**Trinity Grammar School Redevelopment (SSD-10371)  
Response to Submissions**

## ATTACHMENT 1

Figure 3. Proposed new bike parking location (Source: PMDL, 2020)

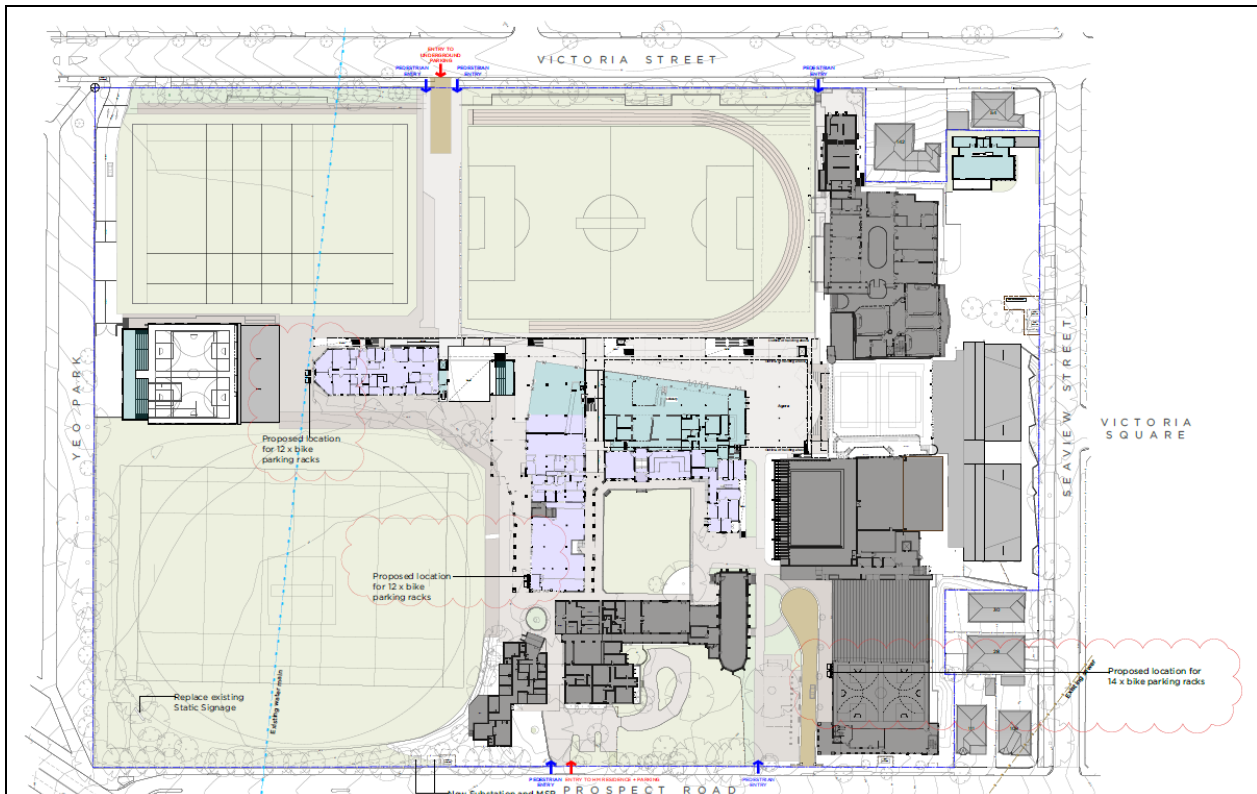
- It is unclear whether bicycle parking spaces with end of trip facilities are provided on site. Adequate bicycle spaces with end-of-trip facilities should be proposed and identified in the architectural plans.

Proposed Signage Lighting Effect

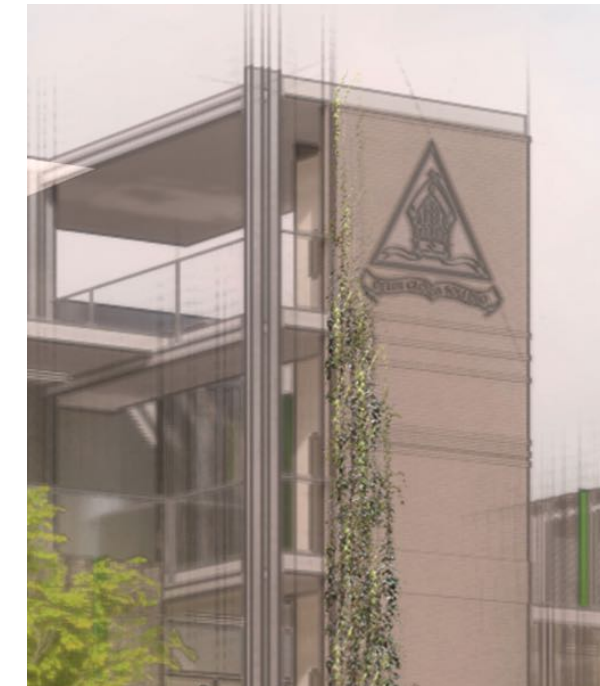
- The application seeks consent for a signage on the western façade of the new building. The details of the proposed signage including a clear elevation and dimensions must be submitted in this regard.
- The EIS states that 'environmentally-sensitive lighting would be designed into the proposed signage'. Details of this lighting including lux levels is to be provided.

**01 ELEVATION**  
Maintenance Building Elevation East  
Scale 1:100

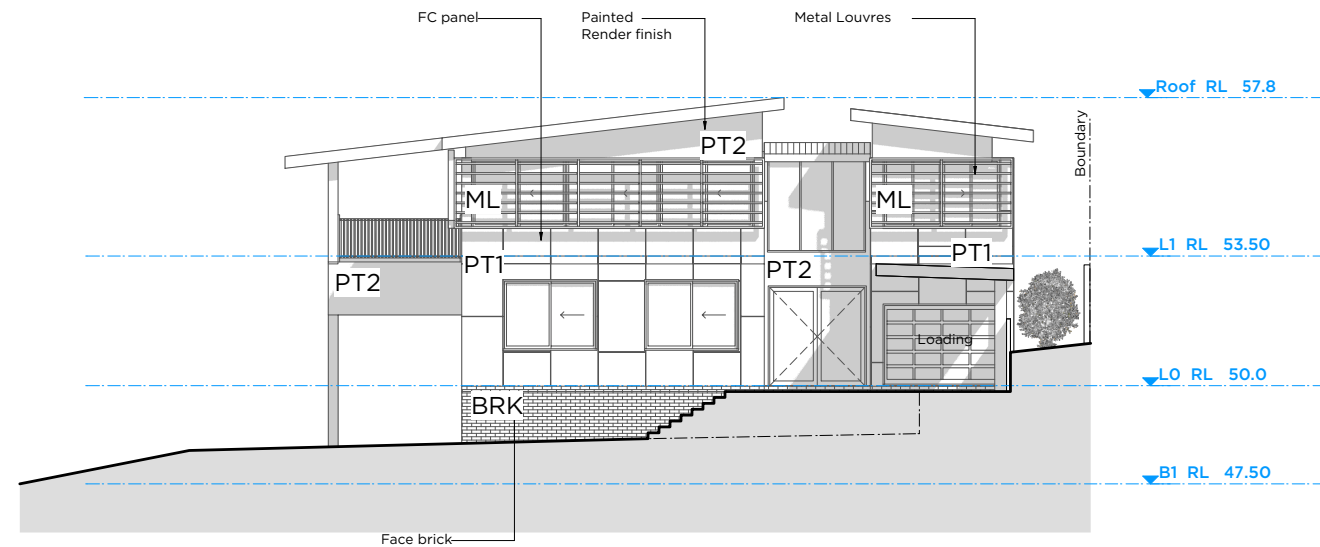
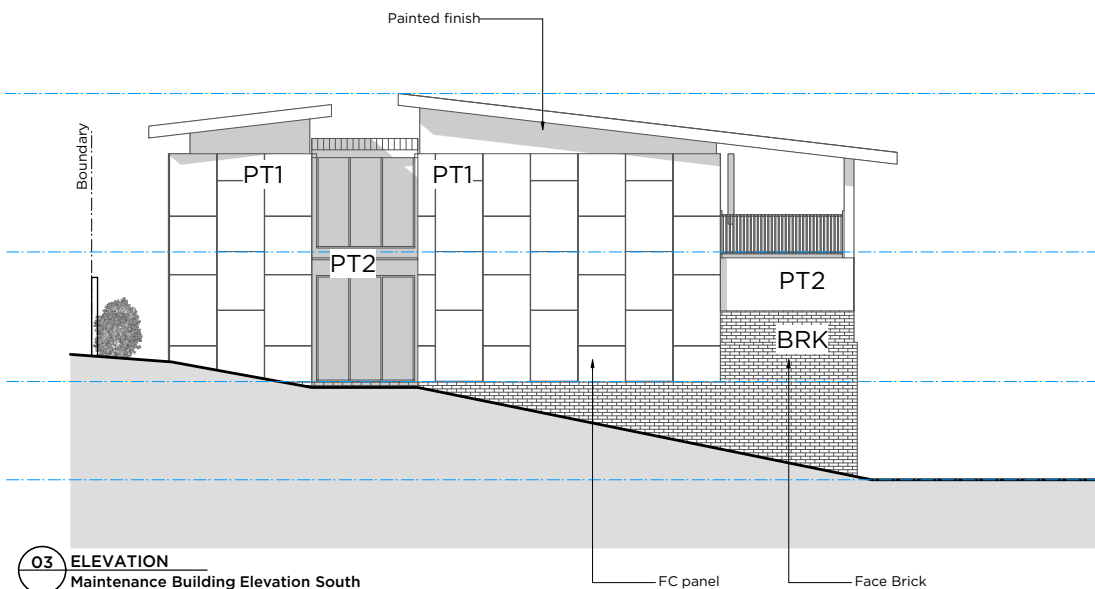
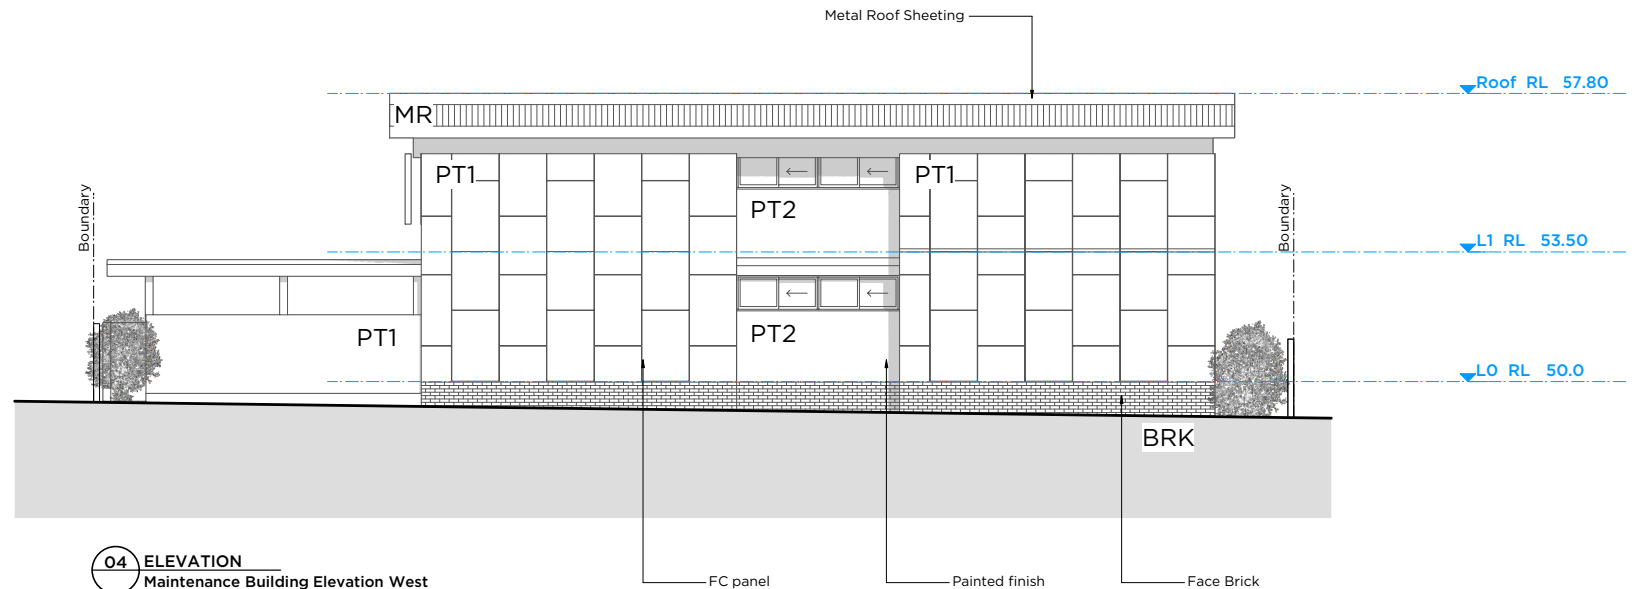
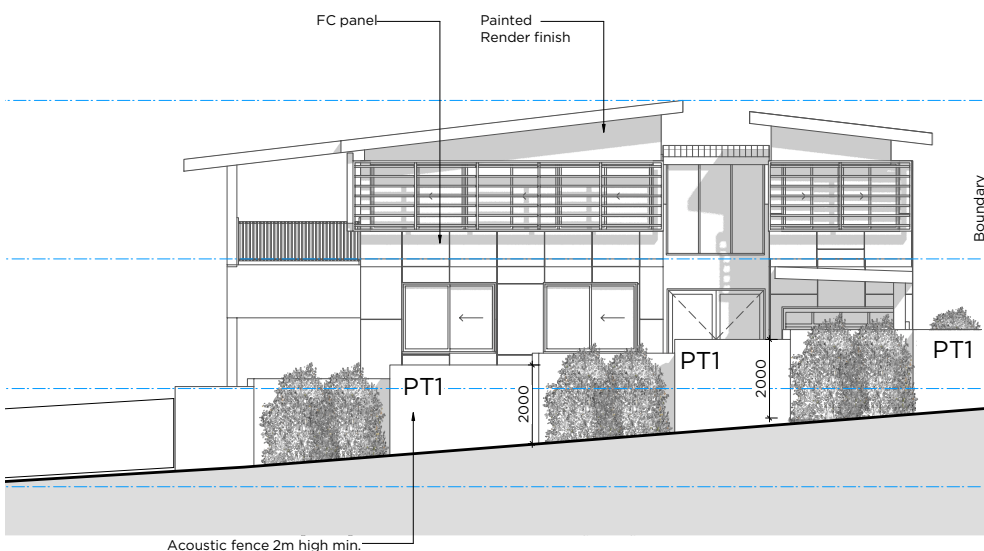
- Details and numbers of the proposed replacement planting (species, pot size and quantity) on site must be included in the landscape plan.
- Details with regards to Seaview Street streetscape is to be provided including elevations and planting in front of the proposed new Maintenance Building to screen its bulk from the street.
- The Arborist report should be updated to include a plan identifying trees to be removed and retained in two separate colours.

- The submitted architectural plans only includes the street elevations. The response to submissions must include updated architectural plans with elevations of all facades of each of the new buildings proposed.
- The submitted shadow diagrams must be updated to include the surrounding buildings to provide a context and extent of overshadowing impacts on the existing buildings within the site as well as neighbouring buildings / dwellings.
- The EIS states that the schedule of materials and finishes have been provided. However, this document is absent in the EIS / architectural plans or any other supporting documents. A schedule of materials and finishes with supporting details must be submitted.
